DECISION DELEGATED TO HEAD OF PLANNING

Application No: H16-1013-21 **Applicant:** W Wood & J Cole
Proposal: Extension & Alterations - re-submission of H16-0525-21
Location: The Bungalow Fulney Lane South Spalding
Terminal Date: 18th November 2021

Drawing
ELEVATIONS - PROPOSED
SITE PLAN - PROPOSED
LOCATION PLAN

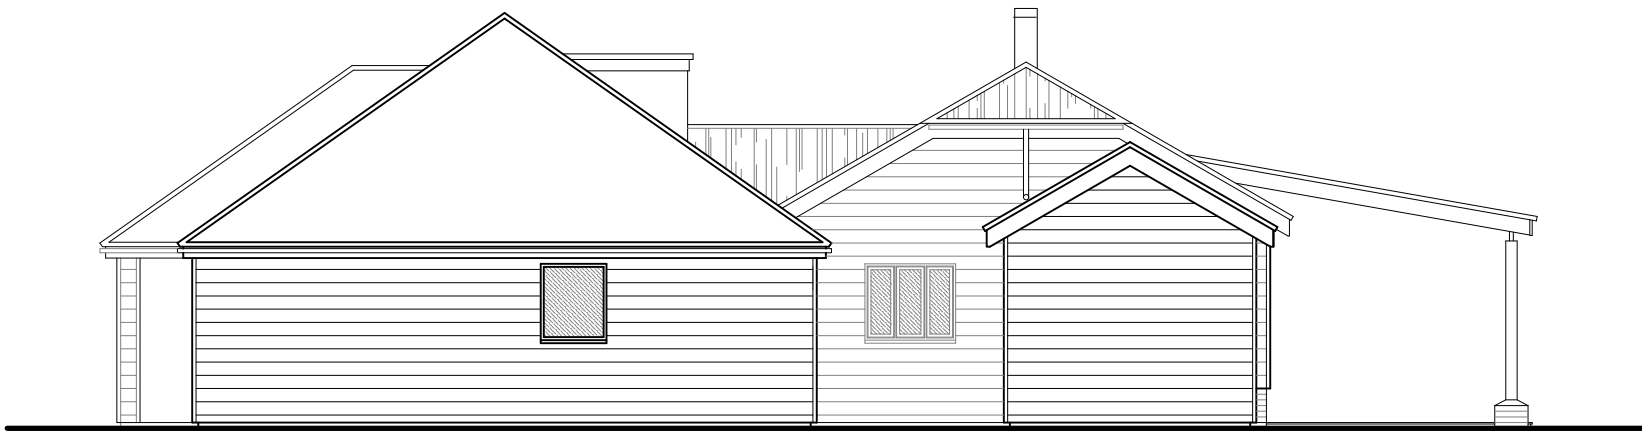
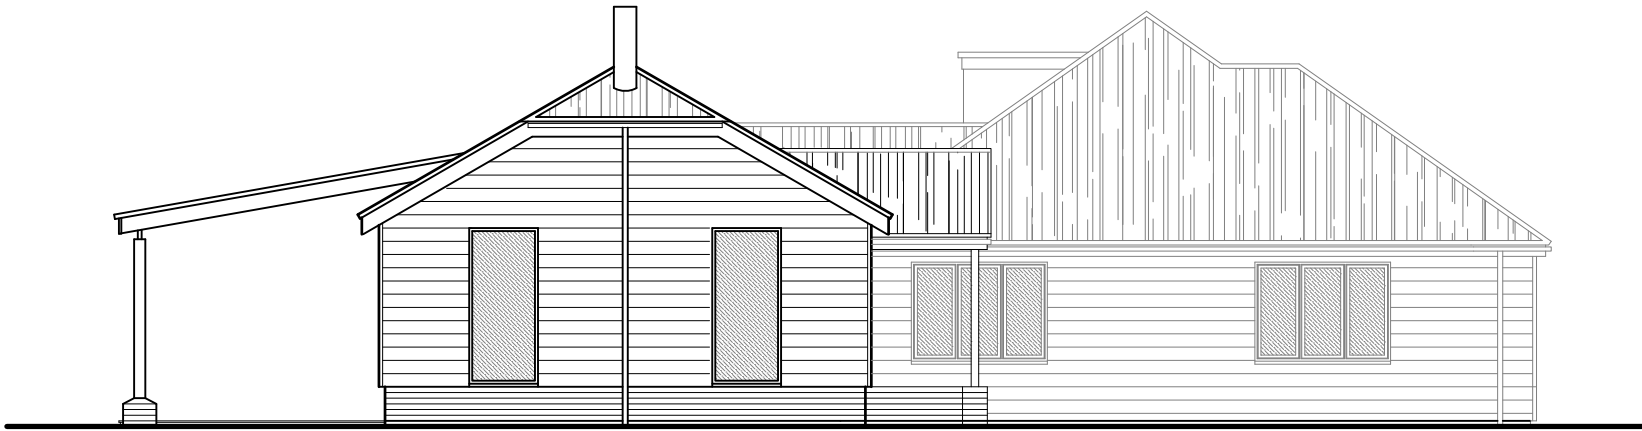
The revised scheme, although still has a significant footprint, can on balance be accepted as the width of the extension has been reduced by some 3 metres. Given there is no strong built character in the immediate area, the proposed extension can on balance be accepted. The ridge height of the extension would be lower than the existing roof ridge, therefore providing an element of subservience.

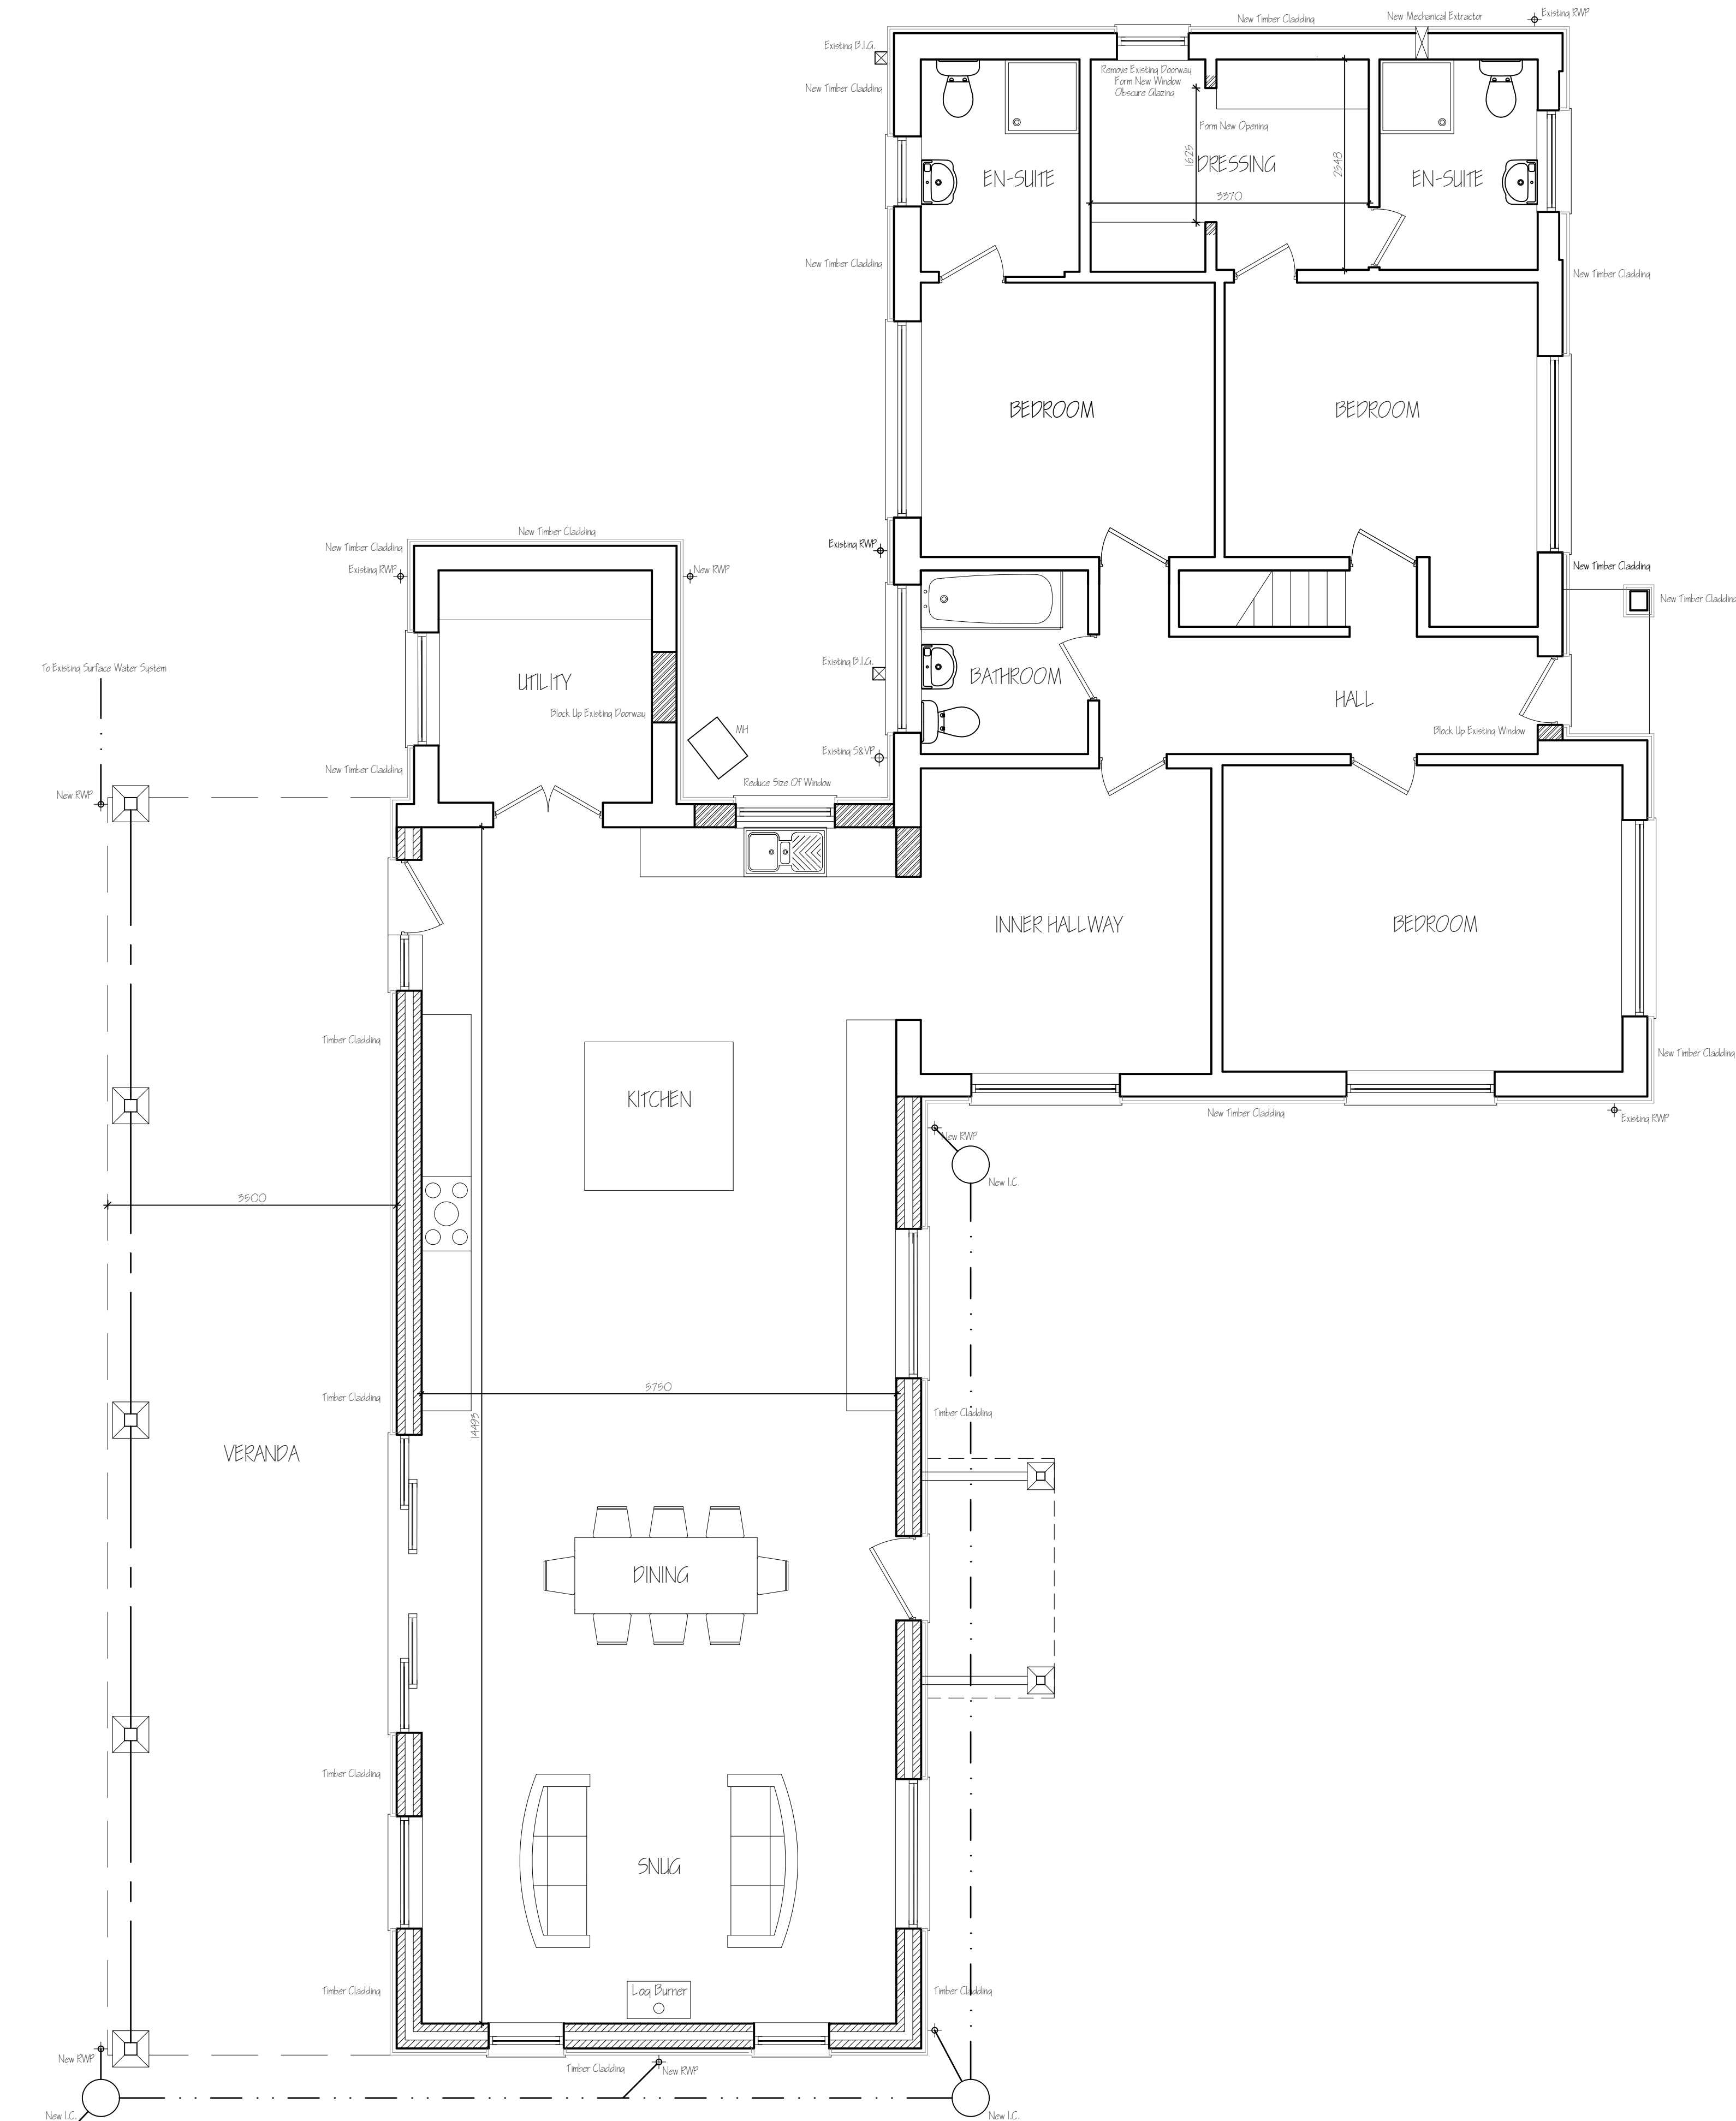
This is a householder application seeking permission for a single storey side extension measuring 11.3 metres (width) x 6.3 metres. The existing lounge is proposed to be changed to a bedroom. The proposed extension would include a kitchen, dining room and a snug.

In connection with Policy 36 of SELLP 2019, Appendix 6 sets out the minimum requirements for car parking provision. The proposal would increase the number of bedrooms in the property from 2 to 3, however, the parking requirement for the site would not increase. 2no parking spaces would be required for the property which can be accommodated in the driveway to the front. As such the scheme complies with the parking standards.
